Case Officer: Hannah Kersley
Reference: FP/16/22/T
Location: 4 Wyke Lane North, Felpham, PO22 8LE
Proposal: 1no. ash tree (T1) - Crown reduction to 12.5m in height and 6m spread
Reasons given: None provided

T1

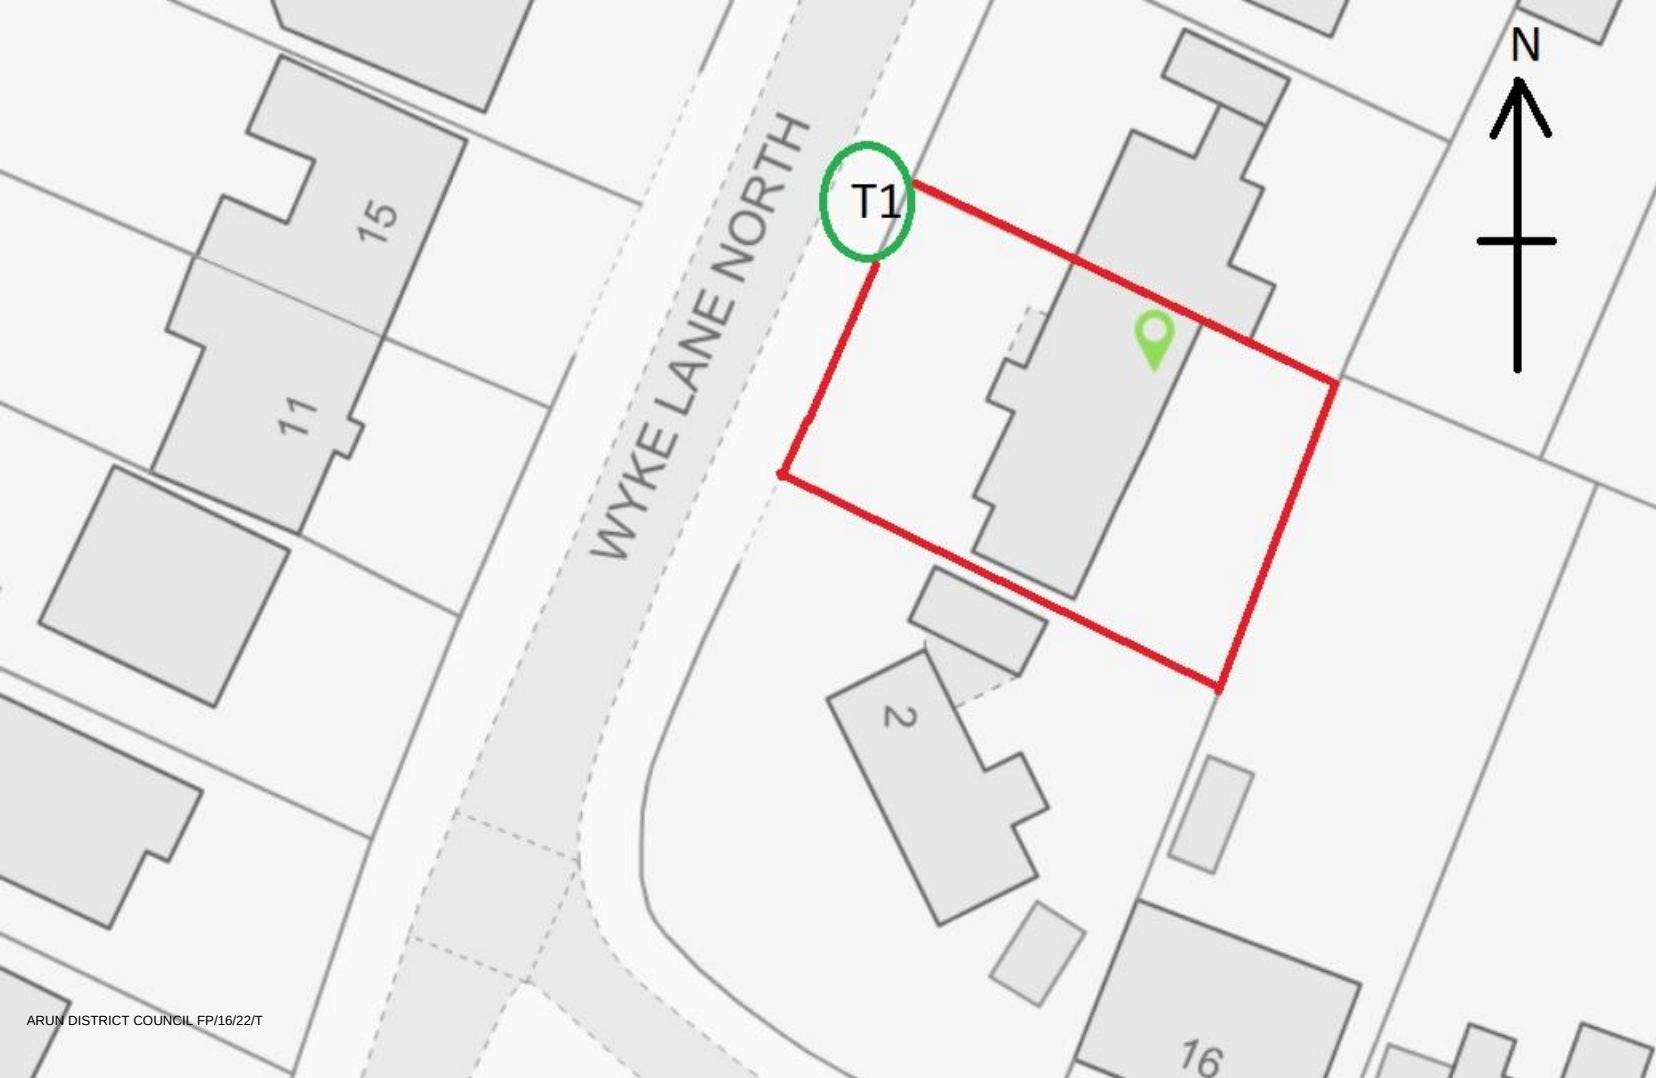
- Outwardly and from roadside this tree appears to be in a fine physiological state and assumed to be so in the absence of any evidence provided to the contrary.
- It is a long-lapsed pollard and has formed a balanced crown profile. It makes a valuable contribution to the street scene.
- The agent and I appear to disagree in our assessment of the tree's overall dimensions, although this does not affect my recommendation.
- The Parish Council's Tree Warden observed impact damage in the crown from high-sided vehicles. If low growth over the carriageway is a concern, the agent and their client should consider the exception for 'dangerous trees and branches' which I have referred to in advisory at the foot of this report.

- This tree requires careful management that respects its vulnerability to environmental changes and potential disease progression.
- No arboricultural justification has been provided for whole crown reduction pruning to any extent, at this time.

- I recommend **REFUSAL** for this application.
